**KIRKLEES METROPOLITAN COUNCIL
INVESTMENT & REGENERATION SERVICE**

Reference No:	2025/62/92566/E
Site Address:	19A, Victoria Street, Heckmondwike, WF16 9LH
Description:	Erection of two storey rear extension
Recommending Officer:	Joshua Merriman

Officer Report – 2025/92566

869 - 003 - REV J

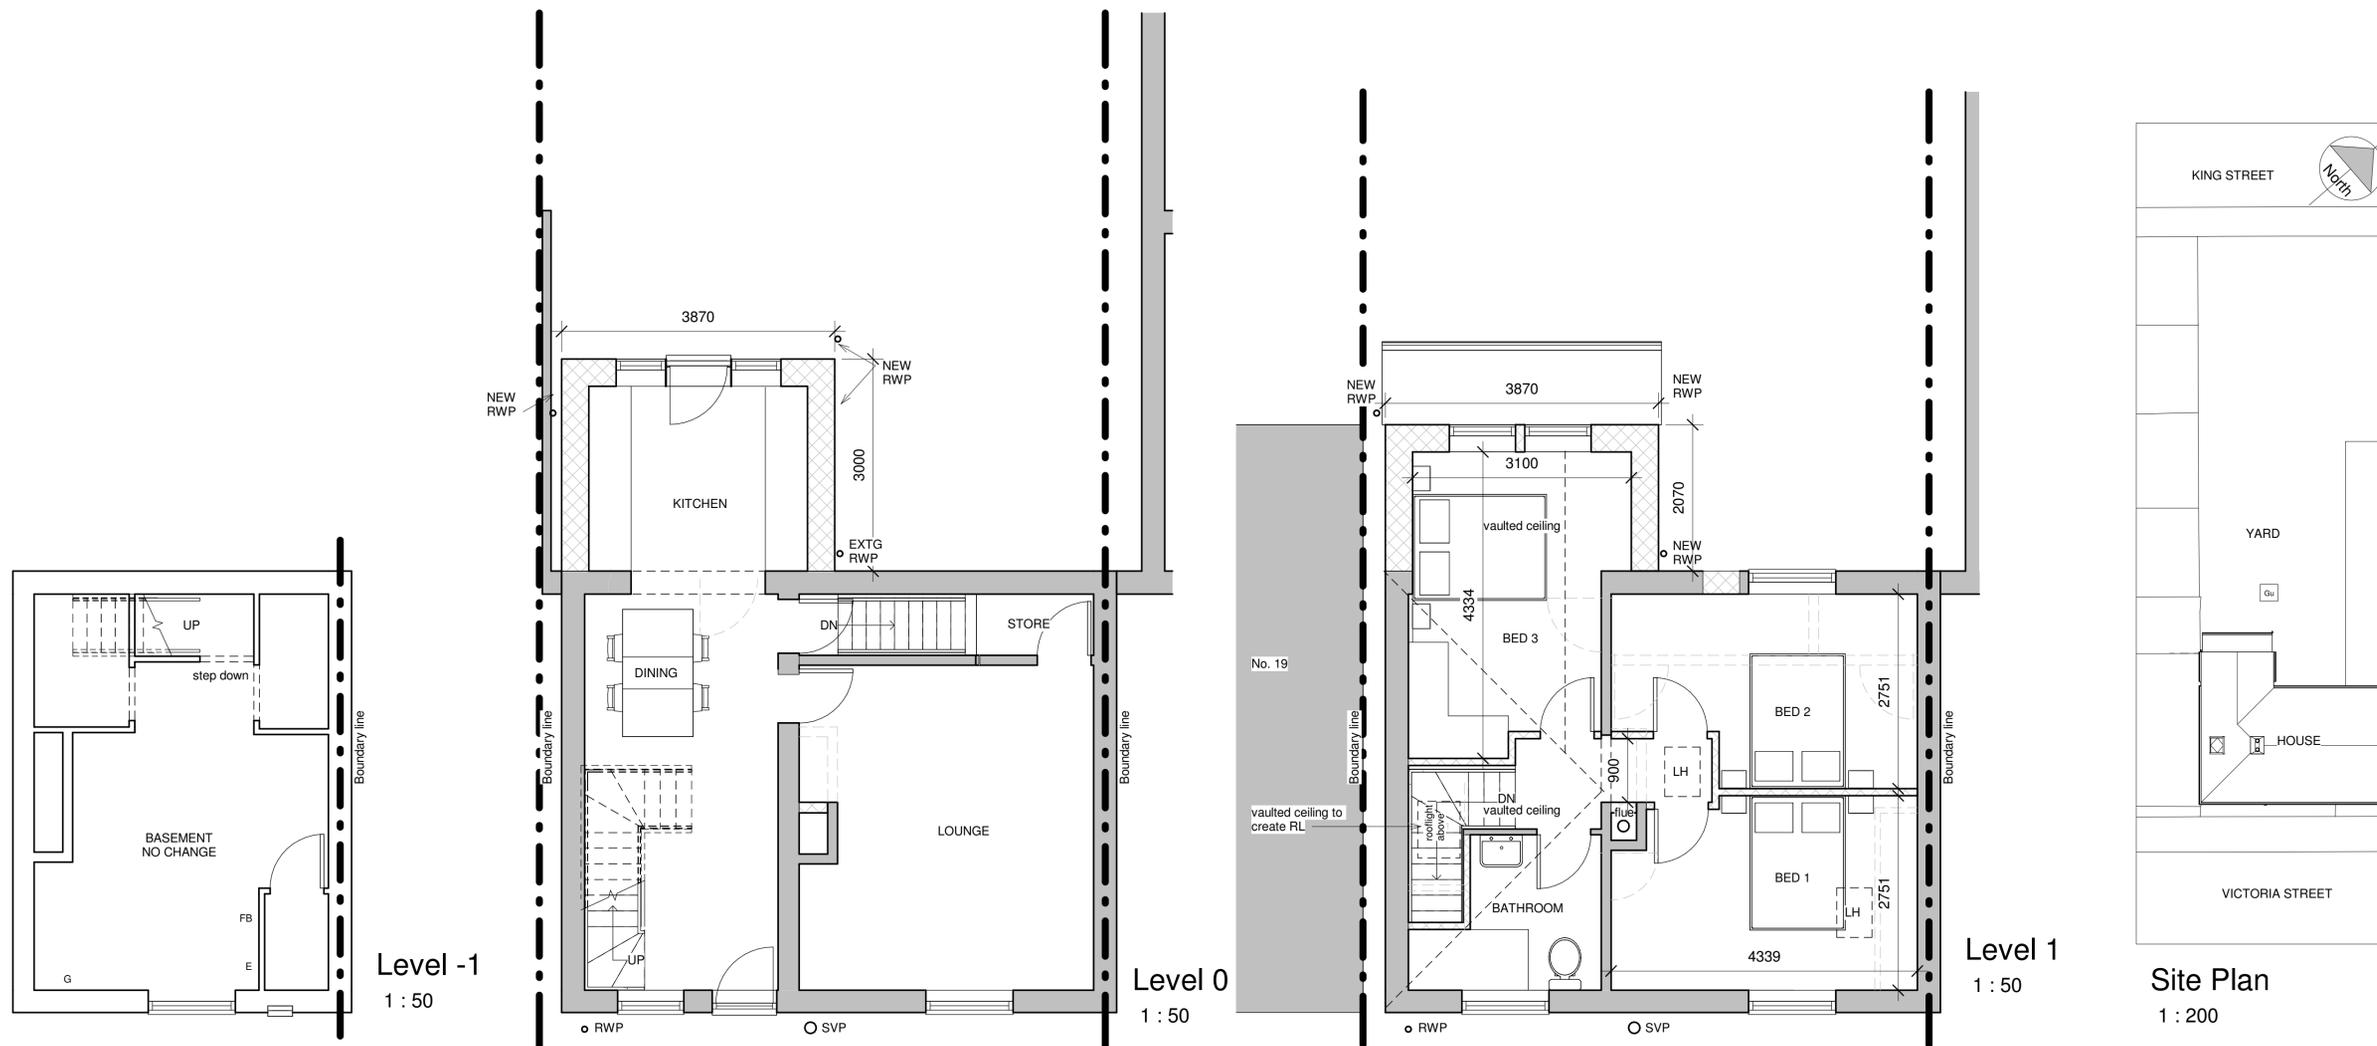
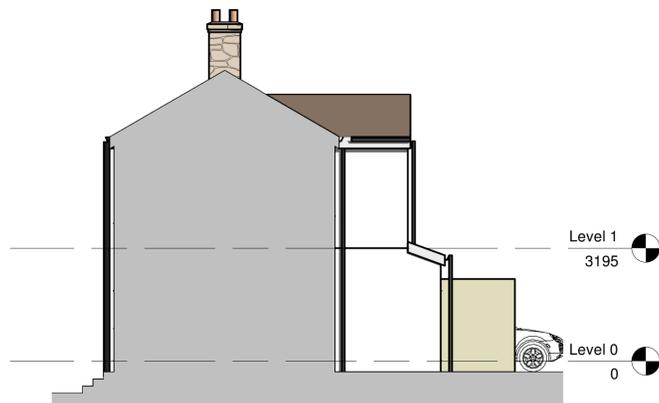
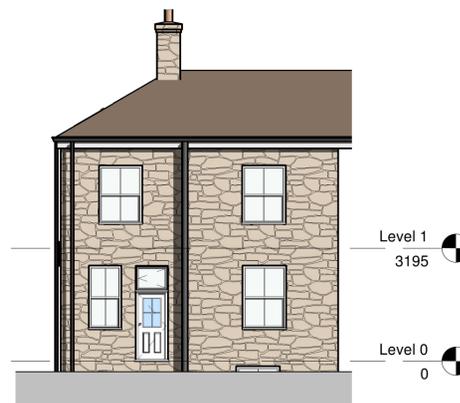
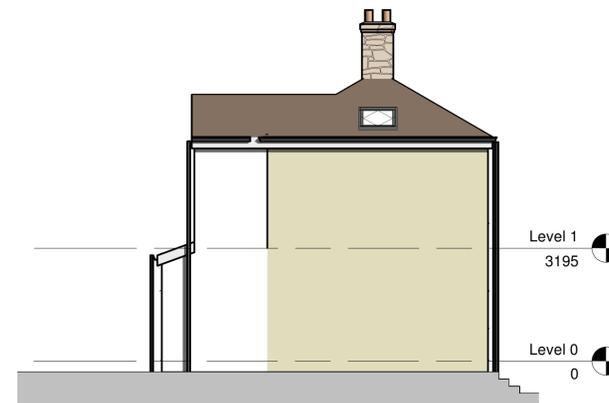
The case officer sought it necessary to request a reduction in the projection of the extension, and ensure the extension was of a suitable width as to have no

significant impacts in the form of overshadowing and overbearing onto neighbouring properties or the shared courtyard area.

01/12/2025 - 869 - 003J - Proposed Plans
